Ms Amy Watson
Team Leader
Metropolitan Projects
Department of Planning and Environment
GPO Box 39
Sydney NSW 2001

State Significant Development Application for Darling Square (formerly referred to as 'The Haymarket') North East Plot, Darling Harbour

Thank you for your letter dated 14 November 2014 regarding the above. Please accept our letter as a joint Transport for NSW (TfNSW) and Roads and Maritime Services comment on the above development proposal.

Figure 12-2: Access to the North East Site

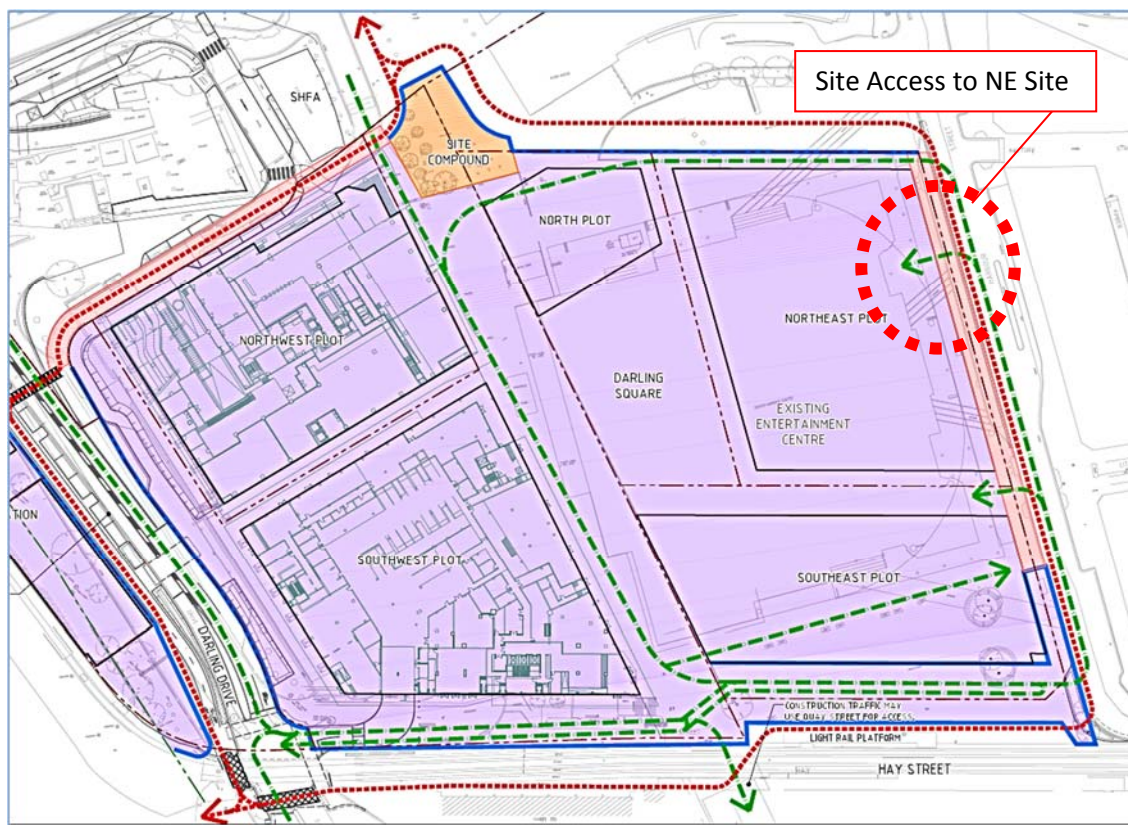
TfNSW requests that a Construction Pedestrian and Traffic Management Plan (CPTMP) be prepared prior to the commencement of construction. The CPTMP needs to:

- Specify any potential impacts to general traffic, light rail, cyclists, pedestrians, bus services and bus facilities operating on roads within the vicinity of the site from construction vehicles during the construction of the proposed works.
- Include the cumulative construction impacts of all the projects planned adjacent to the site and within the Darling Harbour Precinct and the City.
- Include adequate safety and diversion measures be implemented for safe and efficient pedestrian and bicycle movements.
- Identify the measures proposed to mitigate these should be clearly identified and included in the CPTMP.

**AISLE/RAMP
PASSING CHECK
1:200**

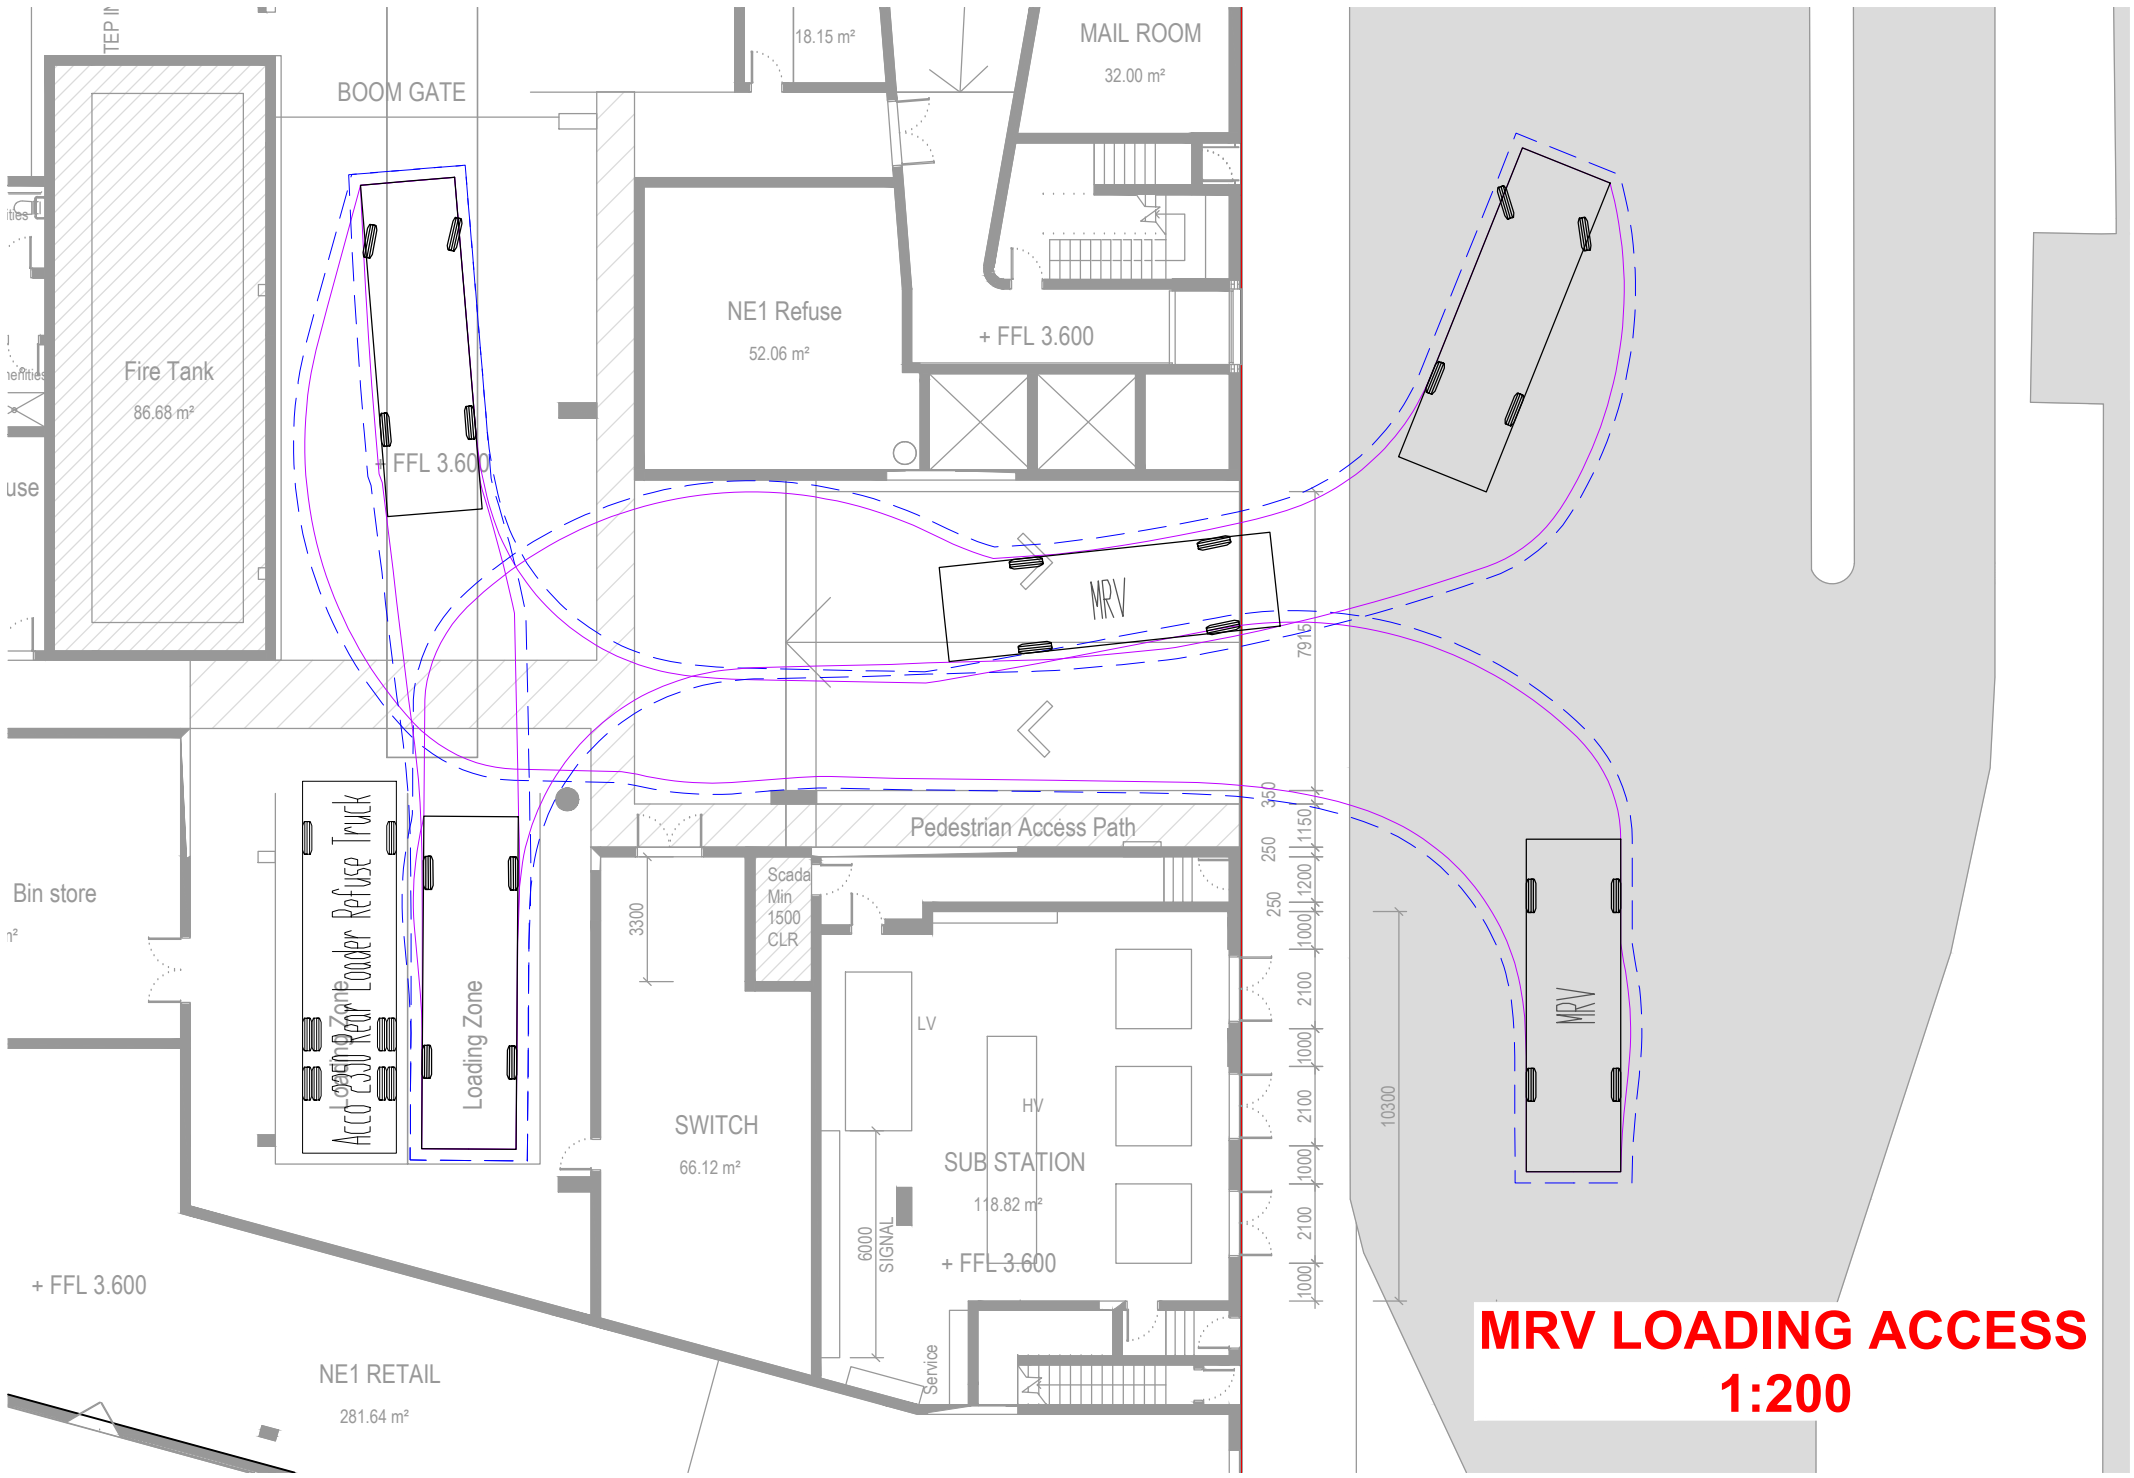
- TfNSW requests that the car park entries/exits are designed to ensure that the future queuing areas and capacity requirements comply with Appendix D of AS 2890.1-2004 and the layout of the proposed car parking areas associated with the subject development (including driveways, ramps, grades, turn paths, sight distance requirements, aisle widths, aisle lengths, and parking bay dimensions) be designed in accordance with AS 2890.1-2004, AS2890.2-2002 and AS 2890.6.
